**From:** [Russell Hand](#)  
**To:** [Brendon Roberts](#)  
**Cc:** [Christopher Corradi](#)  
**Subject:** SSD 7375 - Redevelopment of Harbourside Shopping Centre, Darling Harbour  
**Date:** Tuesday, 1 December 2015 10:09:02 AM  
**Attachments:** [image003.jpg](#)

The City has had the opportunity to consider and discuss the Proponent's request for SEARs for the Harbourside Shopping Centre redevelopment.

SITE OPPORTUNITIES: CONNECTION POINTS

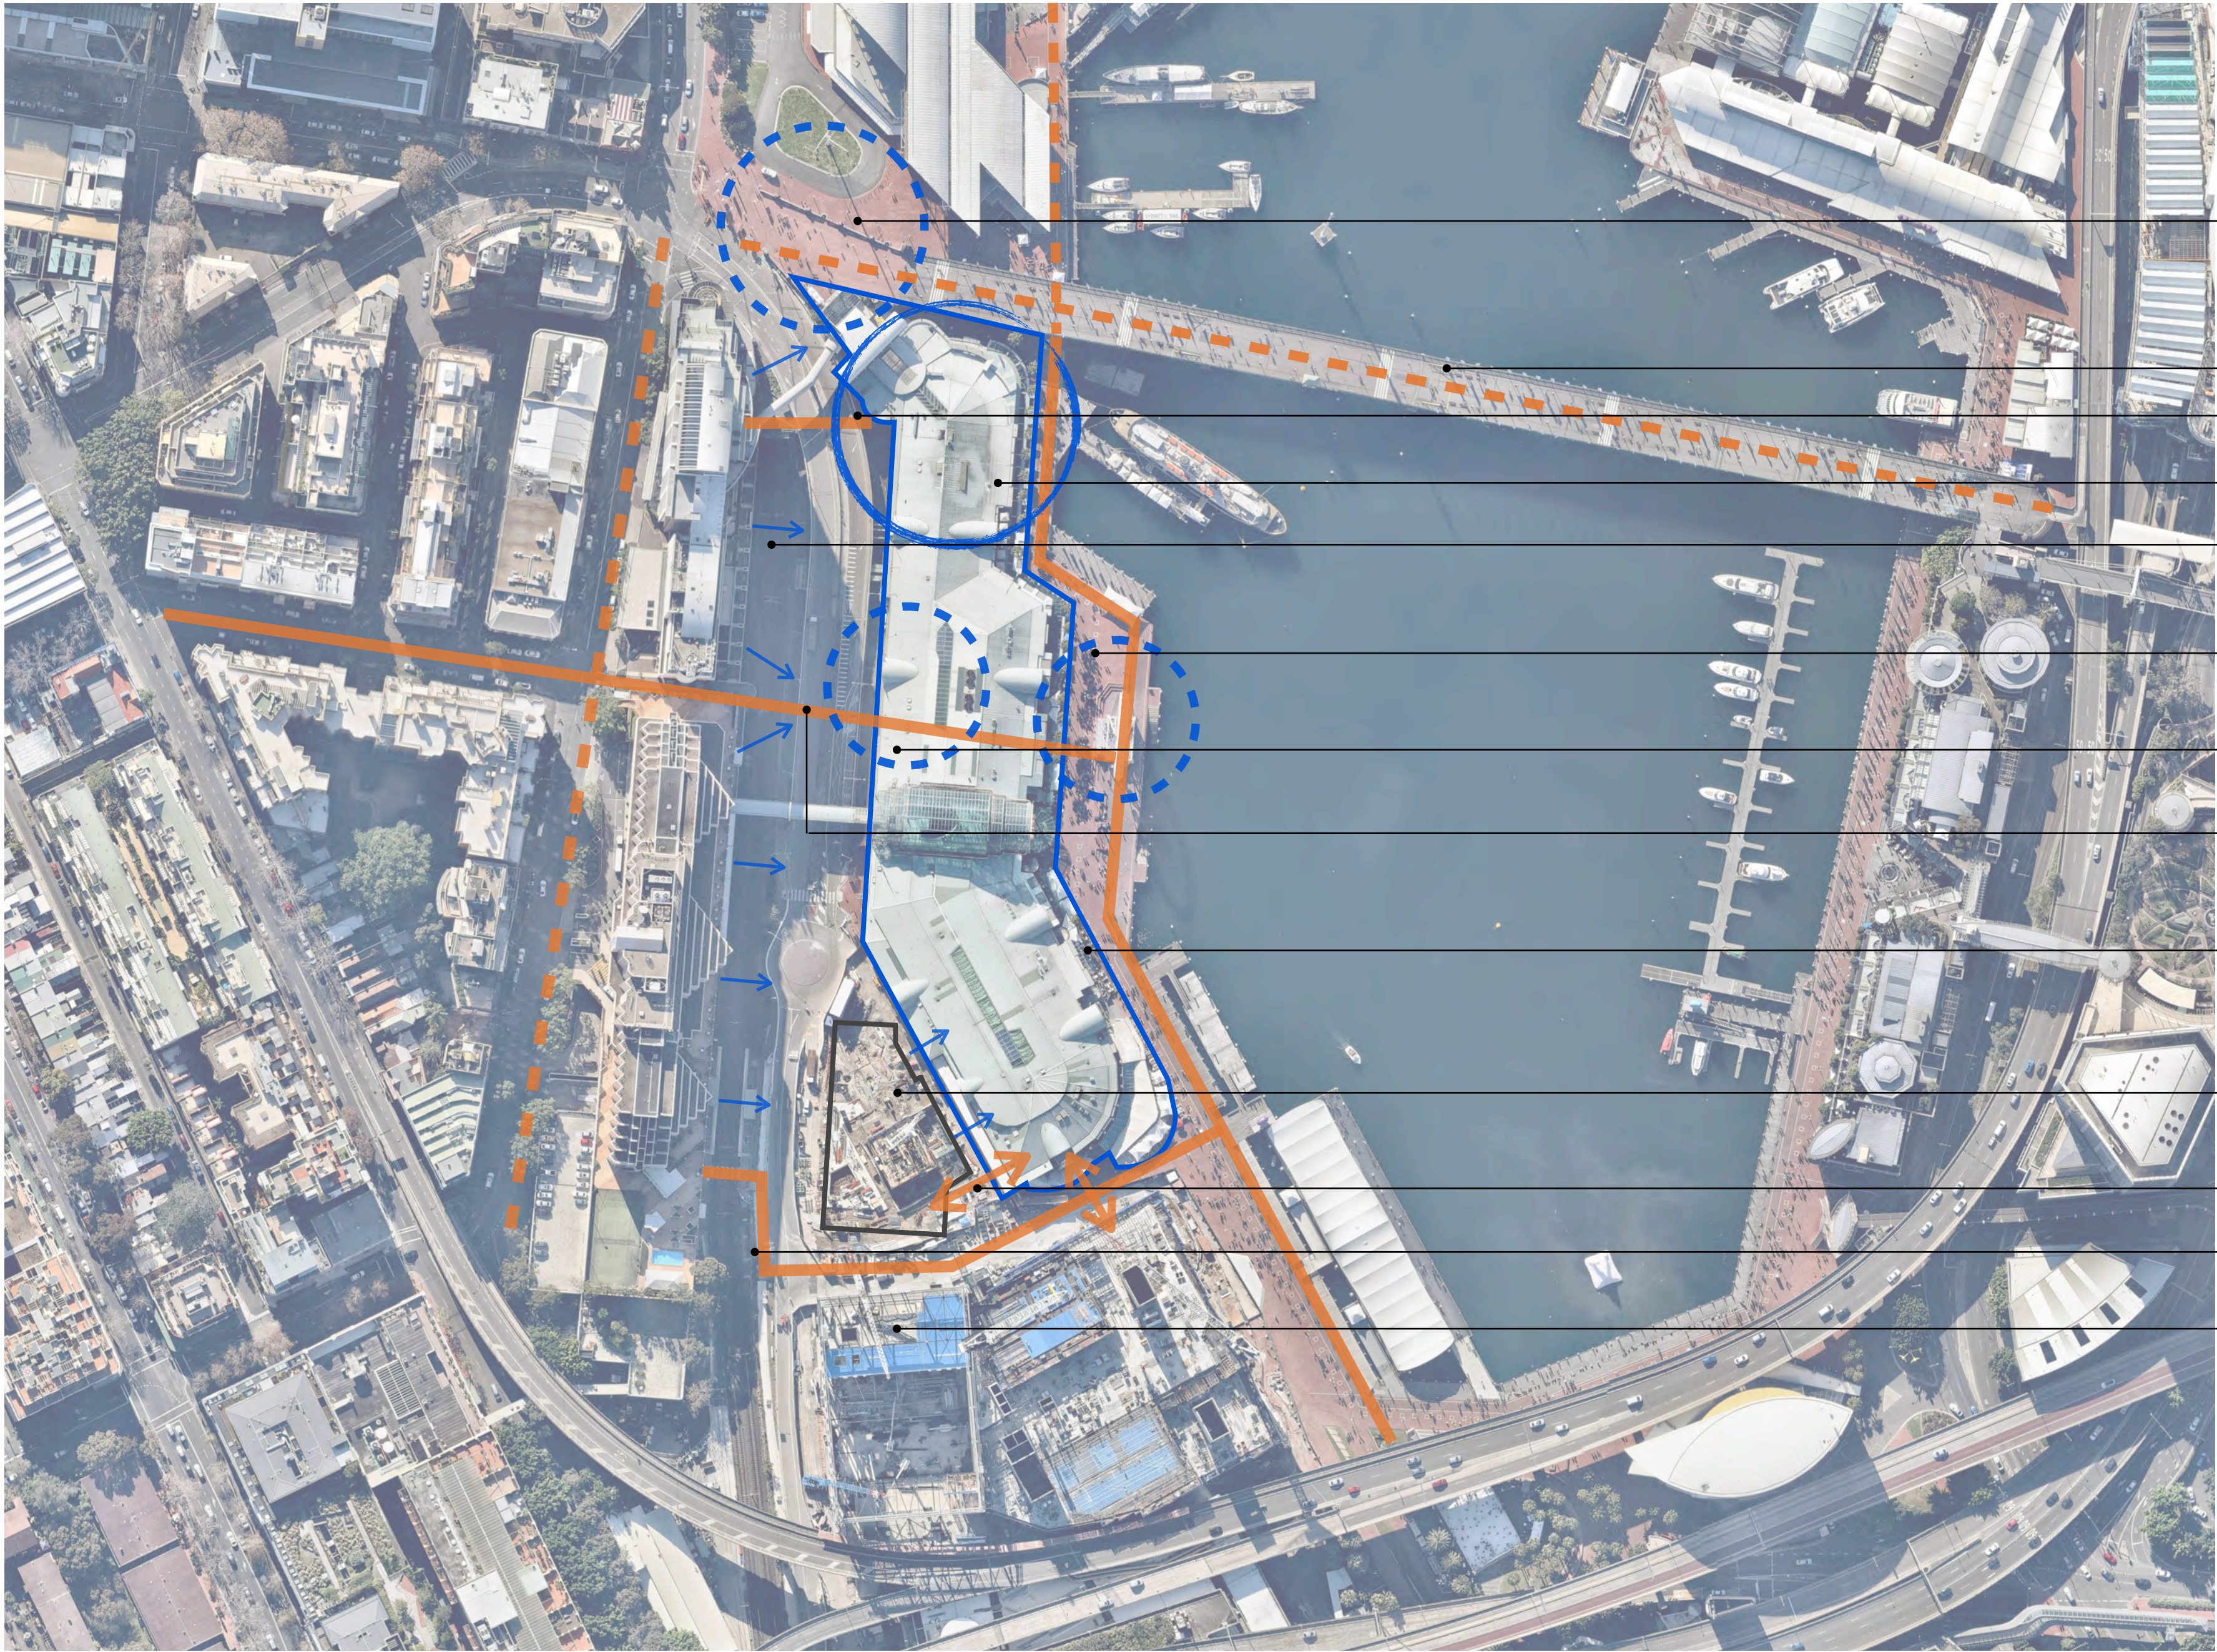
- Consideration to be given regarding the actual pedestrian, tourist and commuter desires for the Bunn Street overbridge connection. The Proponent should study the existing pedestrian desire lines in the precinct to ascertain the merits of the aspect. The concept of the overbridge needs to be challenged and critiqued before proceeding any further.

site analysis and opportunities diagram

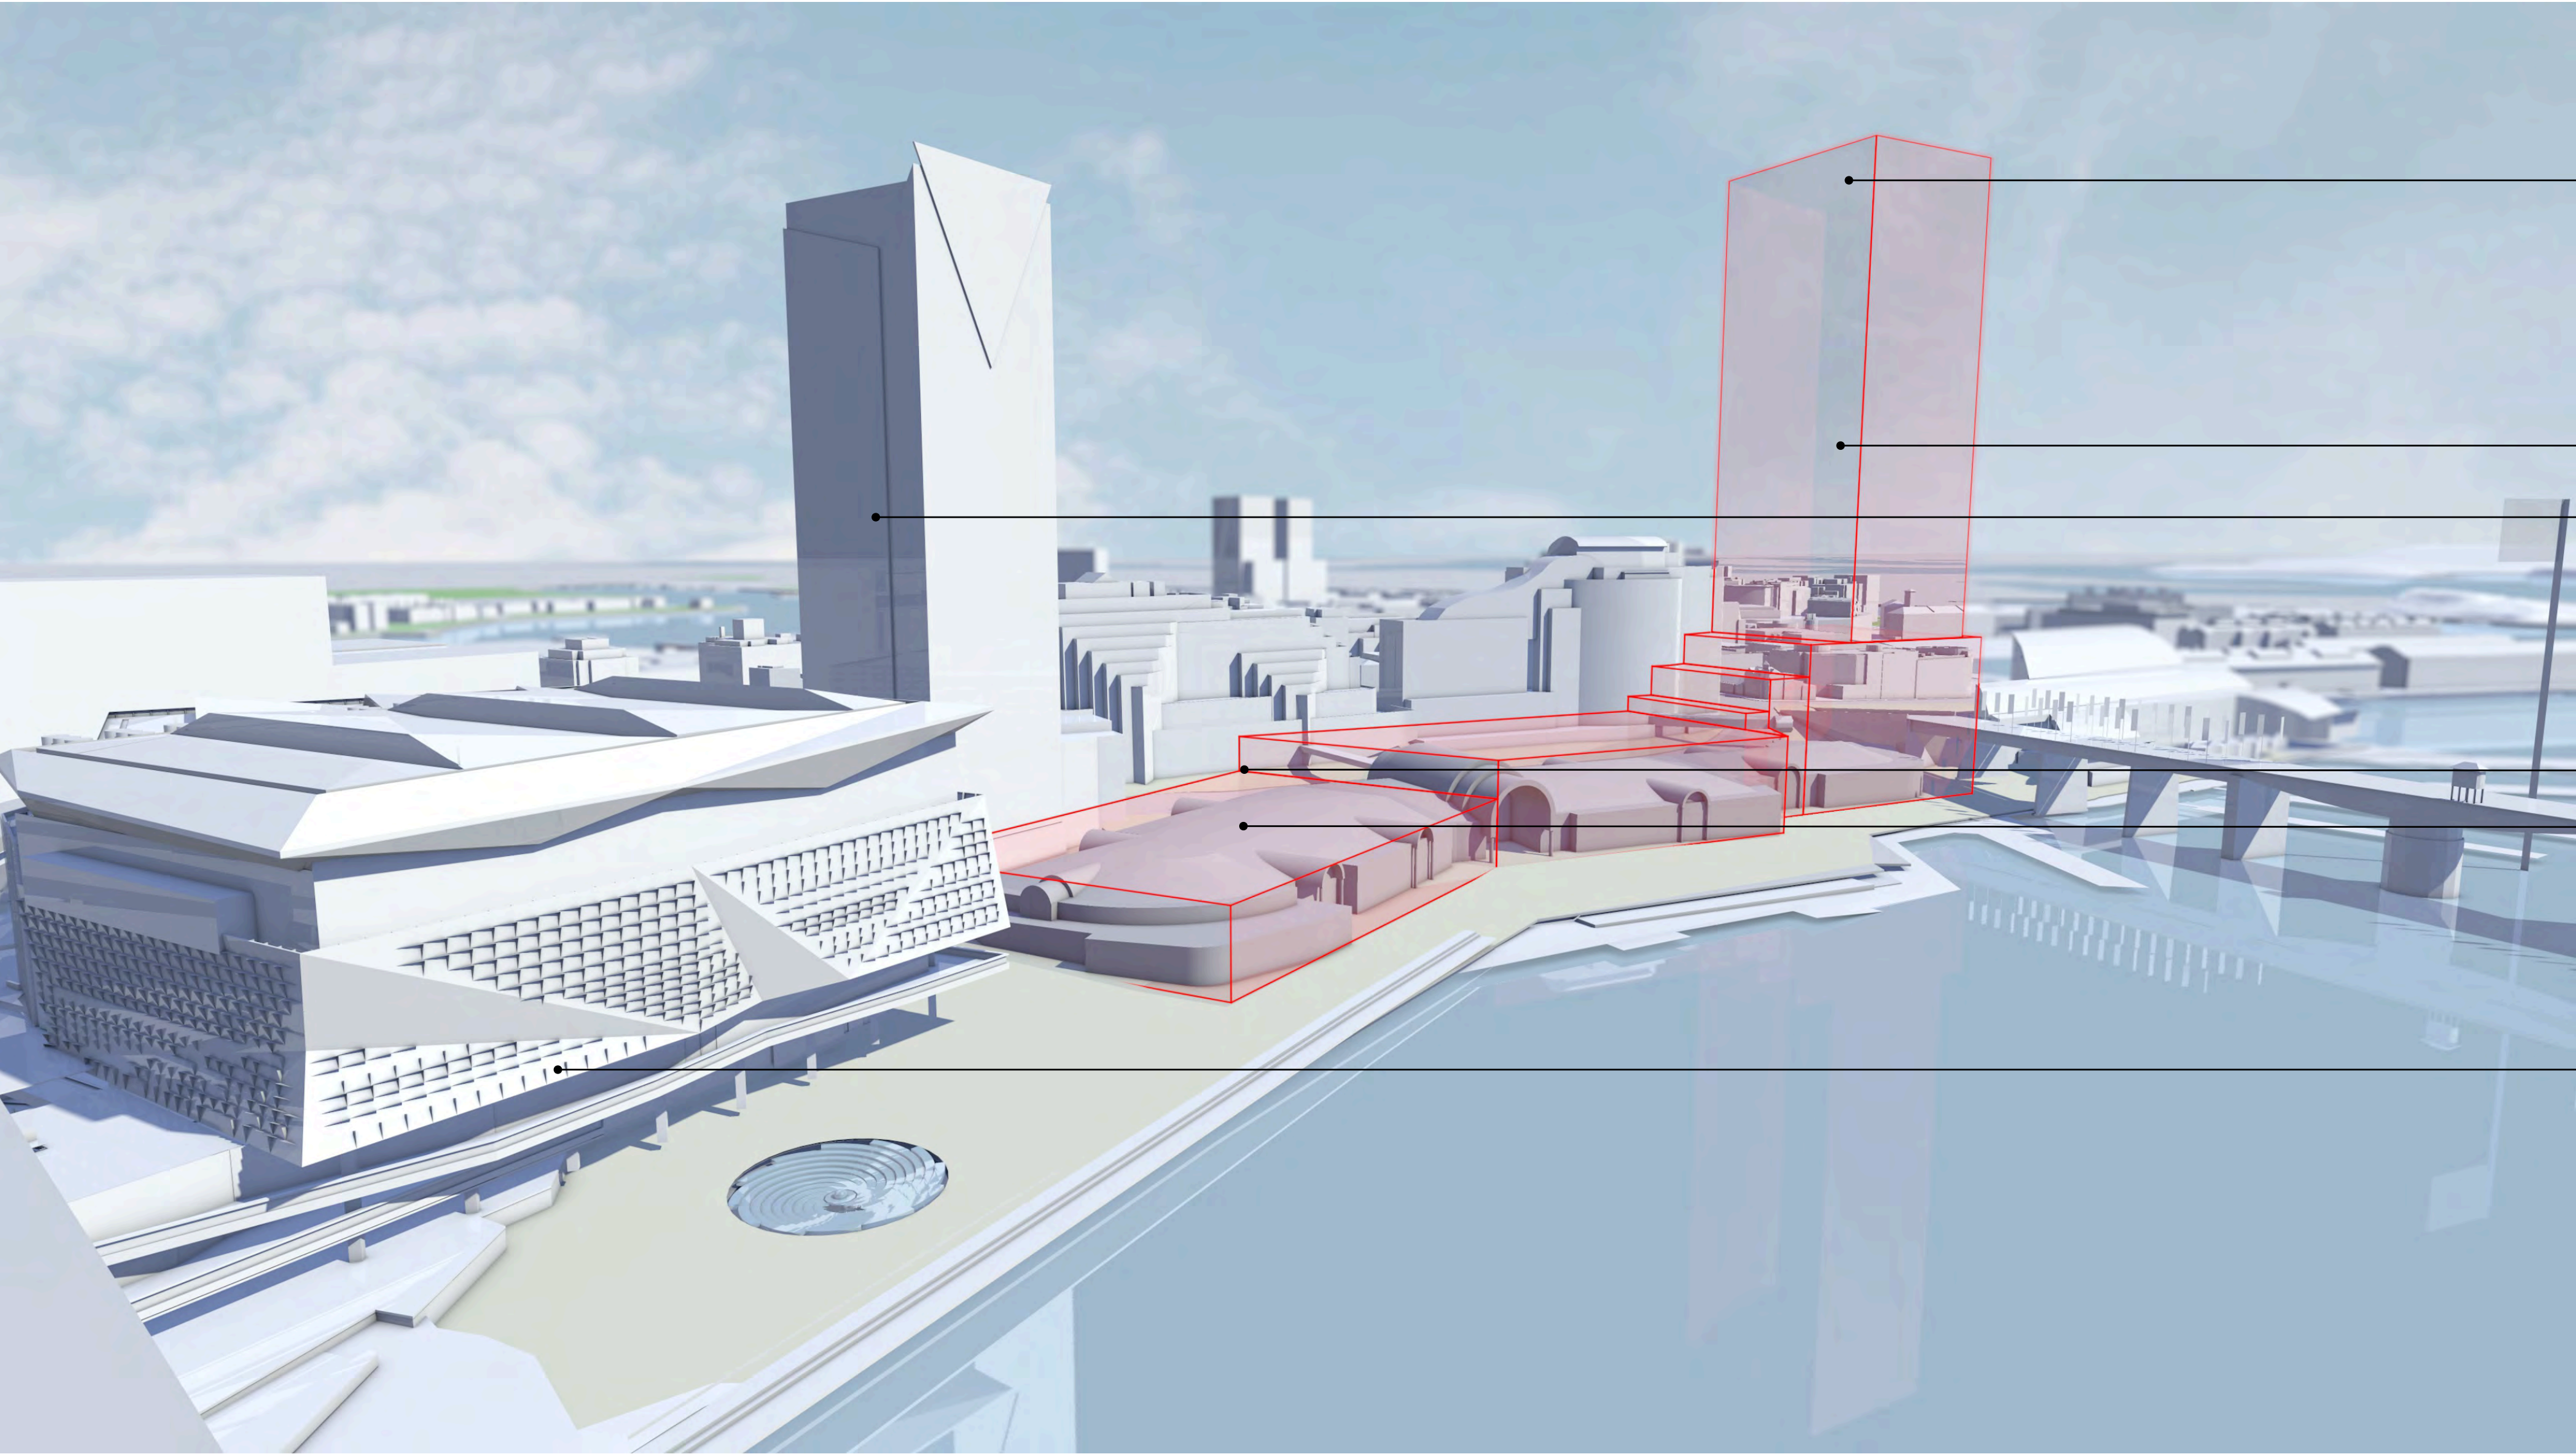
- The proposal appears a shroud to attain a large tower building envelope for office use and later convert that tower entitlement to residential use. In the current property market, the scale of the proposed tower is not required at this time. The SEARs should include a requirement that the Proponent enter into a Voluntary Planning Agreement to confirm the office land use of the SSD application and no permanent residential use.

- The site is considered more suitable to lower scale campus style office accommodation, as is the dominant built form of the Ultimo / Pyrmont peninsula.

- In the absence of any planning controls for appropriate building height, floor space and design quality, the proposal should be subjected to the same rigorous processes under Sydney Local Environmental Plan 2012 as apply in the surrounds. This would include a competitive design process to embed design excellence in to the concept proposal, particularly for the tower concept, but also to find cutting-edge retail design concepts.
